# **SUBMISSIONS REPORT**

**SSD - 10831778**

Sydney Children's Hospital Stage 1/  
Children's Comprehensive Cancer  
Centre

**HEALTH ADMINISTRATION CORPORATION**

1 EXISTING SHADOWS - JUNE 21 - 9AM
1:1500

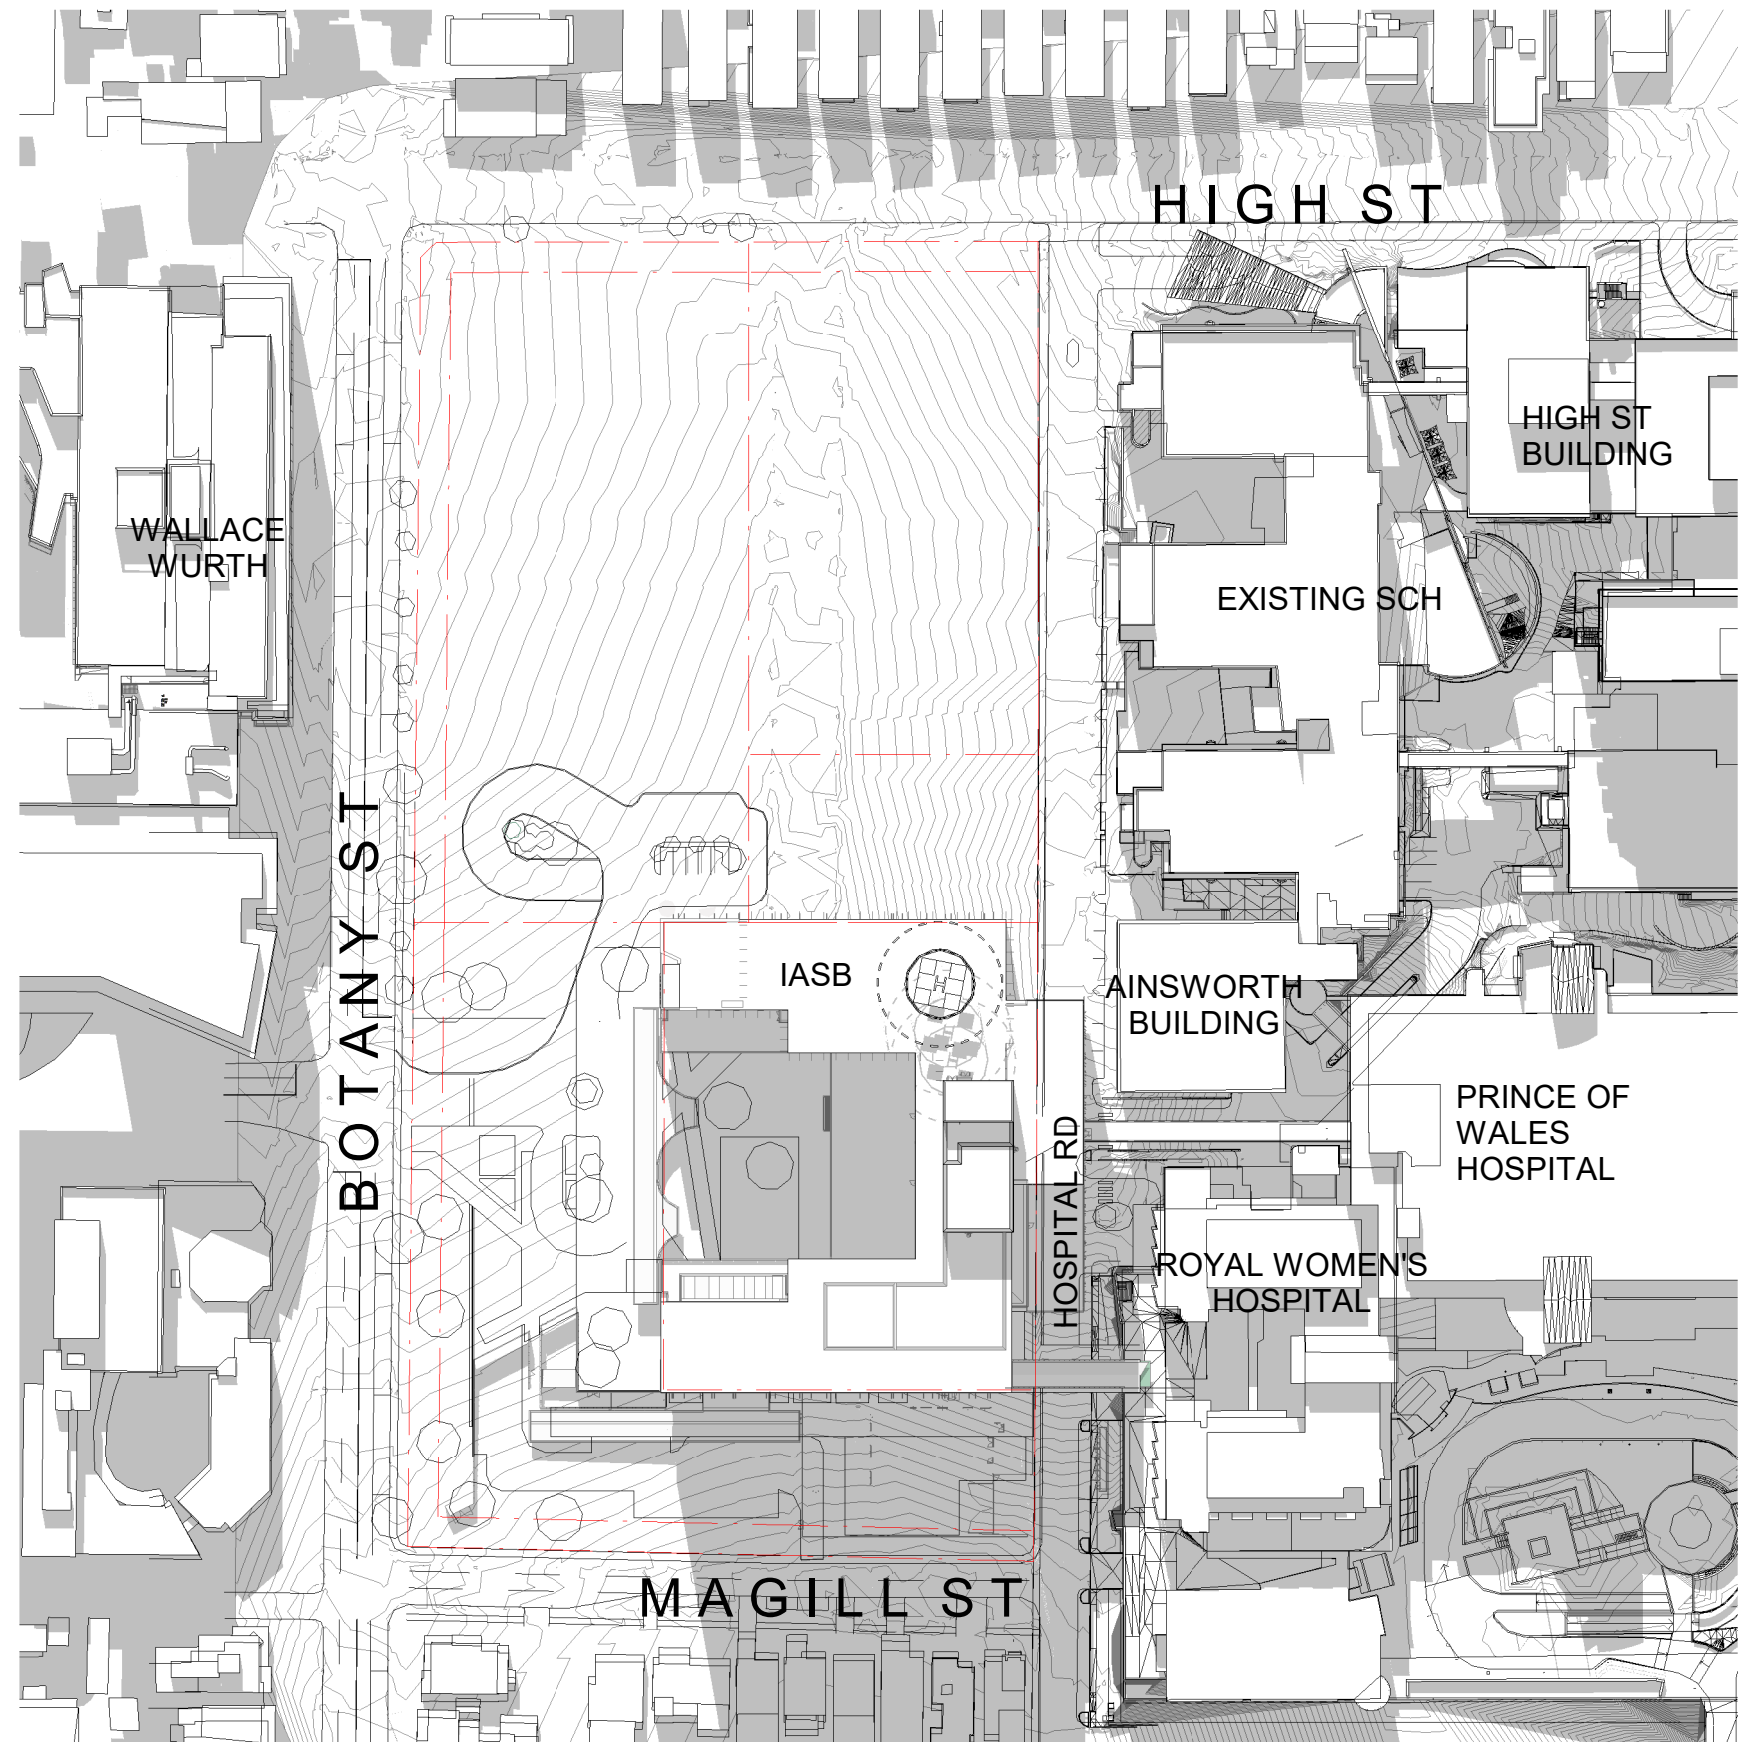
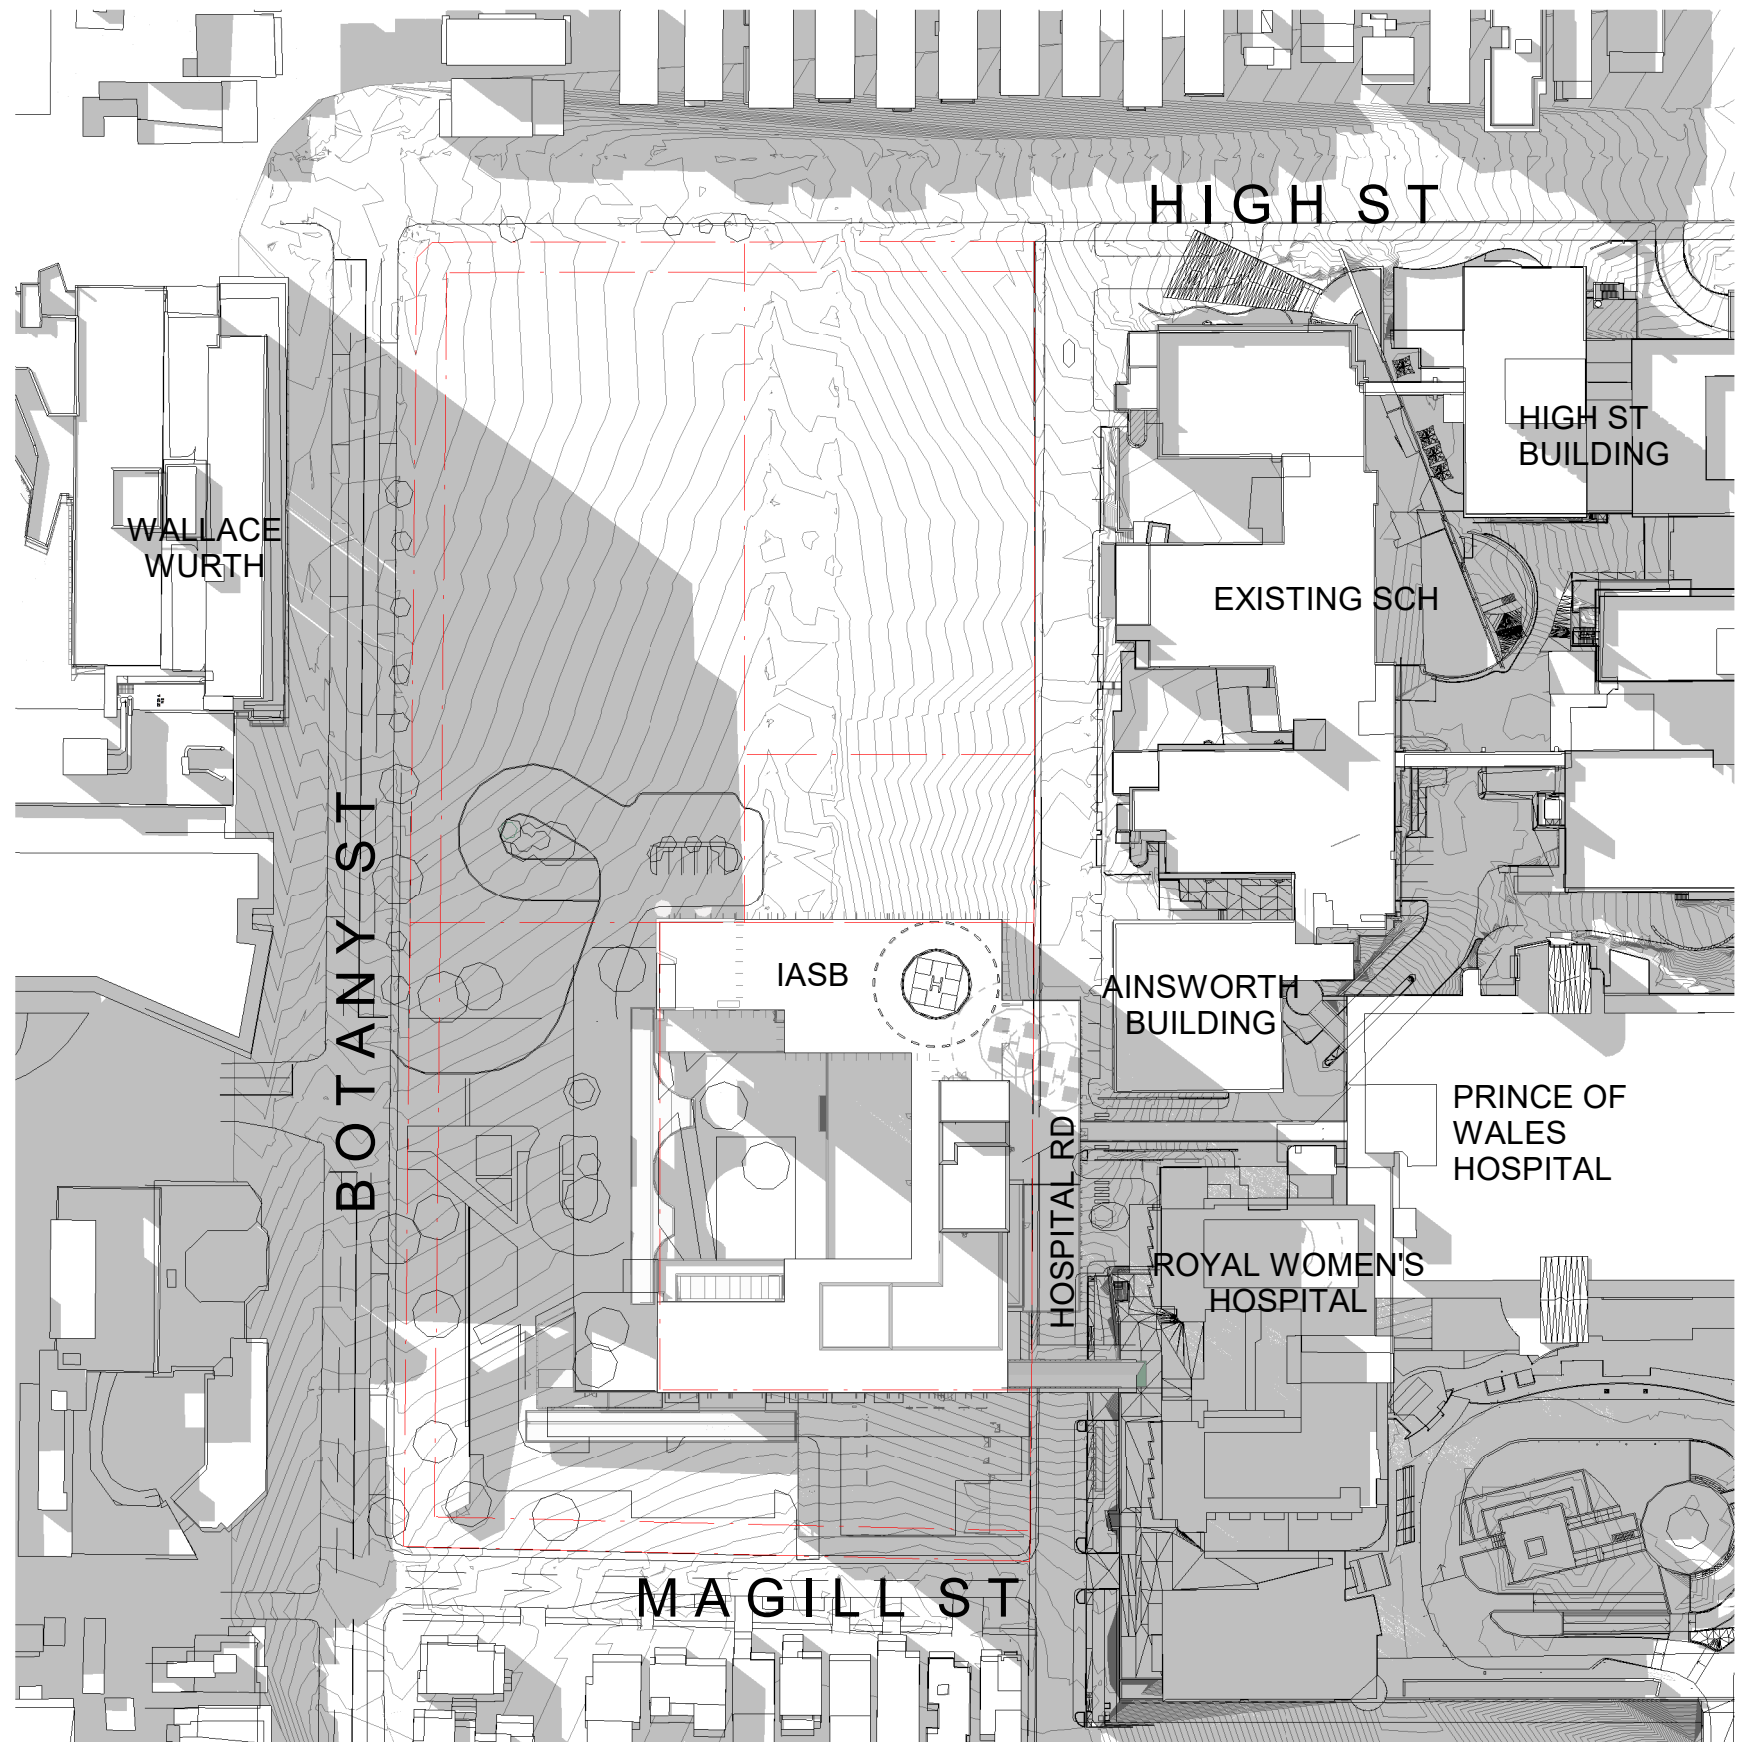
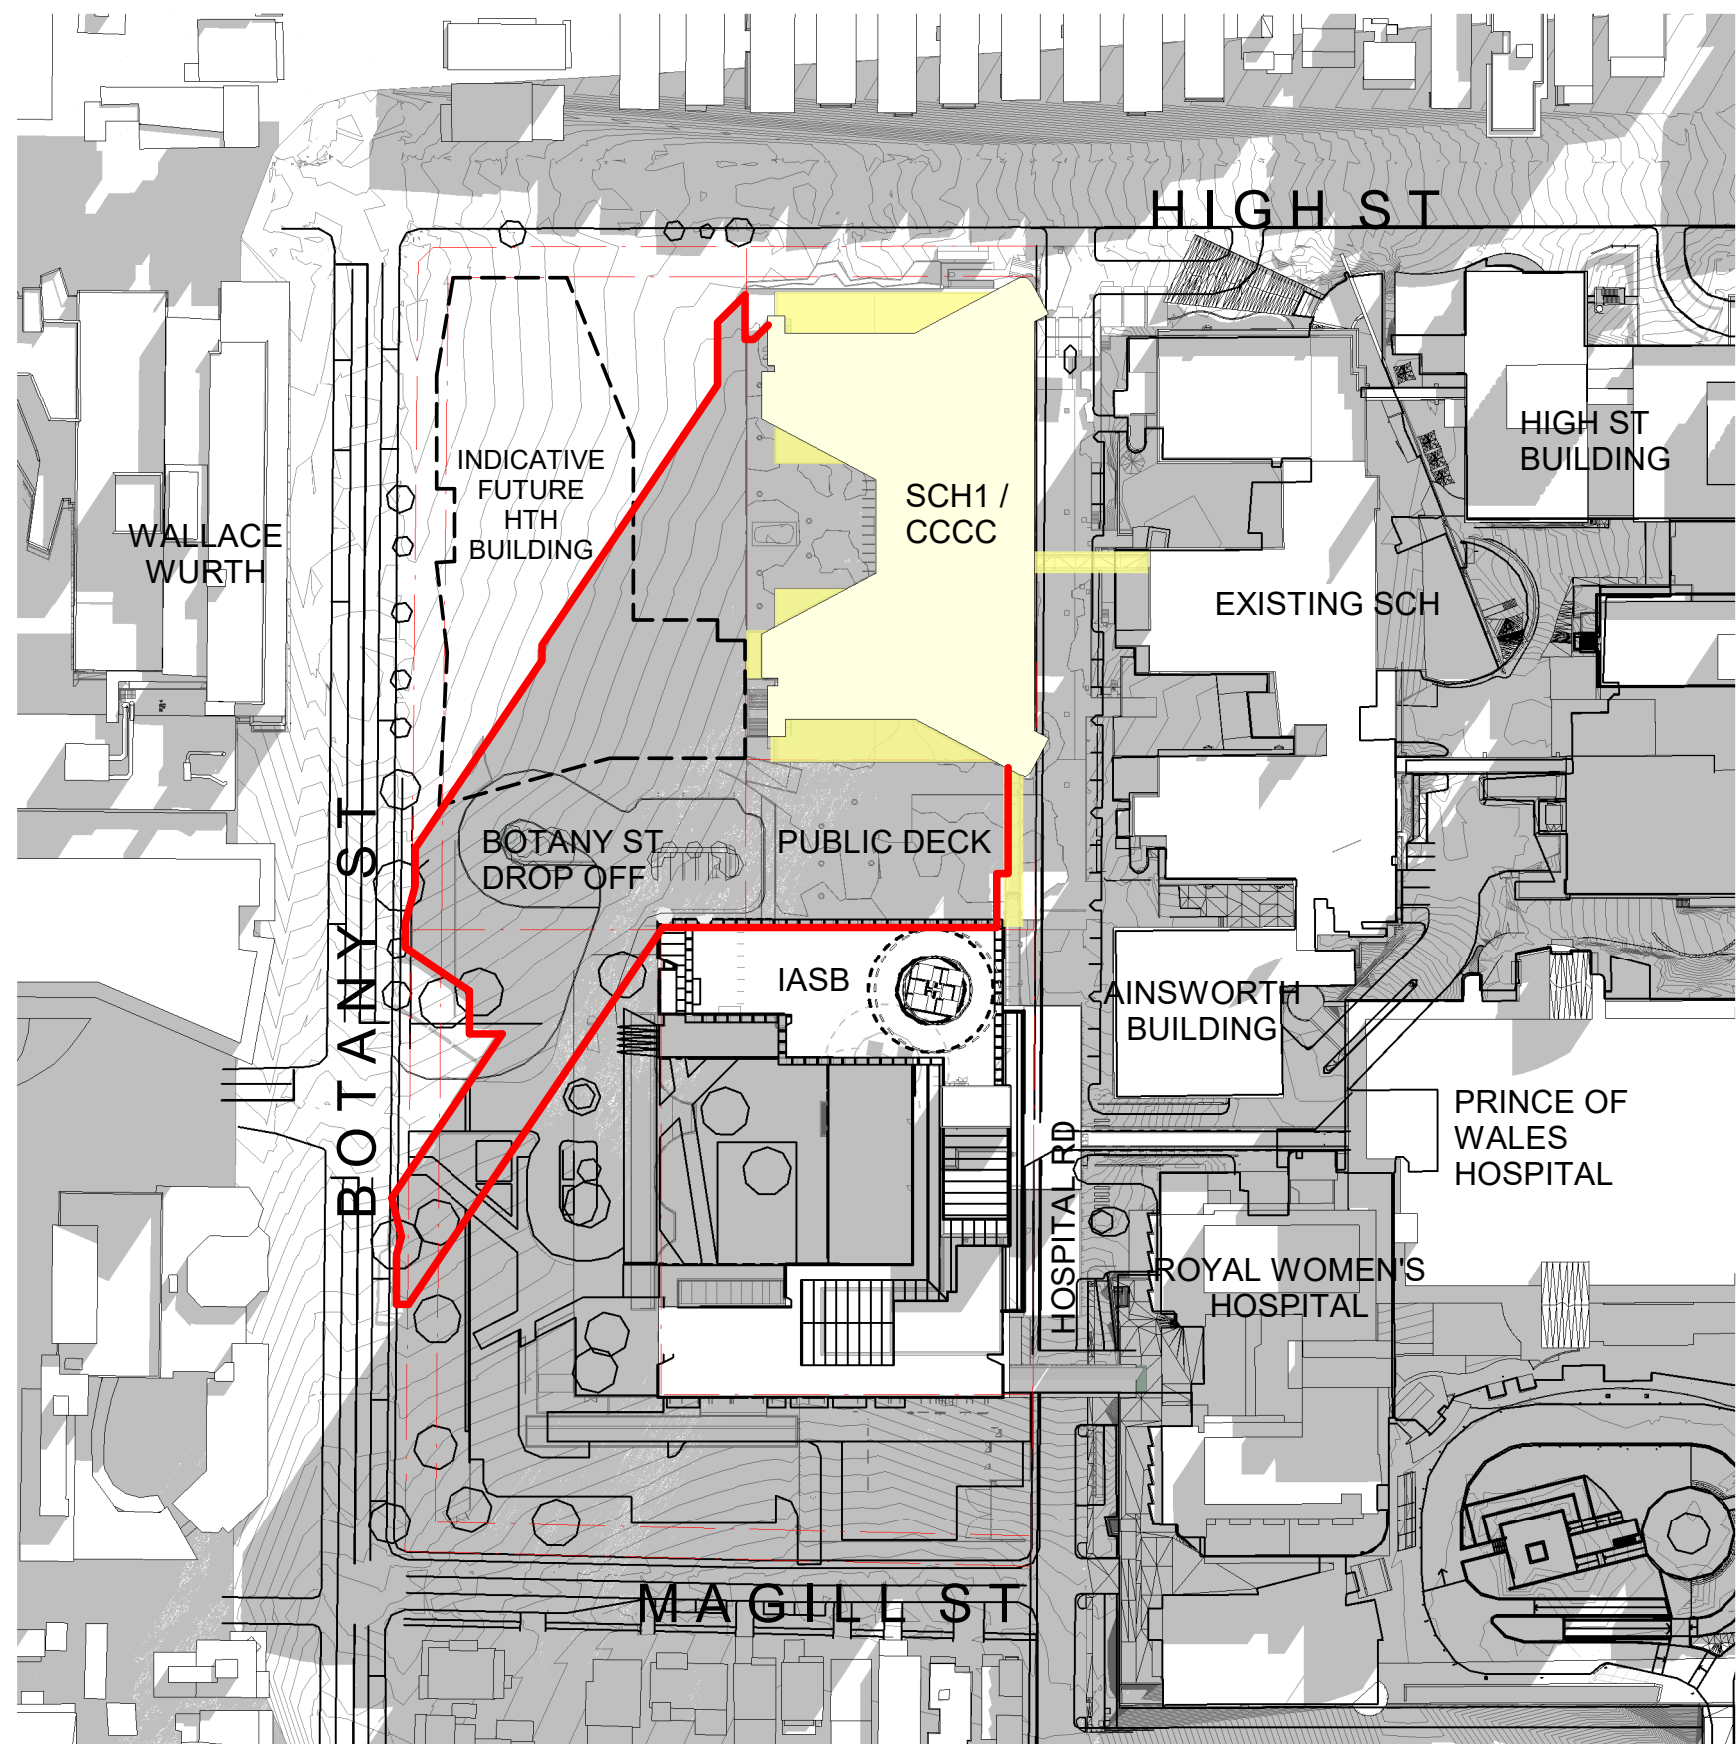
5. Amenity of Childrens' Play Area	The Department is concerned the children's play area will be heavily overshadowed and visually enclosed by surrounding built forms. The provision of an attractive outdoor space for patients of the Children's Hospital is considered an important aspect of the amenity of the building. Therefore, provide further details, visualisations and hourly solar access studies (incorporating shadowing from the proposed HTH) to demonstrate how a high level of amenity would be achieved to the proposed space. If a high level of amenity is not achieved, consideration should be given to supplementing this play space with additional attractive and safe open space for patients such as utilising the podium roof to create additional open space for patients.	<p>The children's play area in the southern podium is not the sole area available for children's play. It is supplemented with additional opportunities for informal play and discovery in both the central courtyard area, as well as along the eastern podium. These includes areas that do receive generous solar access- the northern landscaped area adjacent to High Street and the northern terrace on Level 01.</p> <p>BLP has prepared hourly shadow diagrams showing the shadows cast by SCH1/CCCC and HTH. At the winter solstice the Childrens' playground will be in shadow. However, the outdoor play space will be shaped to provide opportunities for engaging and diverse experiences to occur for ages 0-18 years, as well as families and caregivers. The design team is also working with Yerrabingin and engaging with local indigenous communities, both elders and children, to develop opportunities for this space to become meaningful and playful, and respond directly to the outcomes of the community.</p>	<b>Appendix C and Appendix D</b>
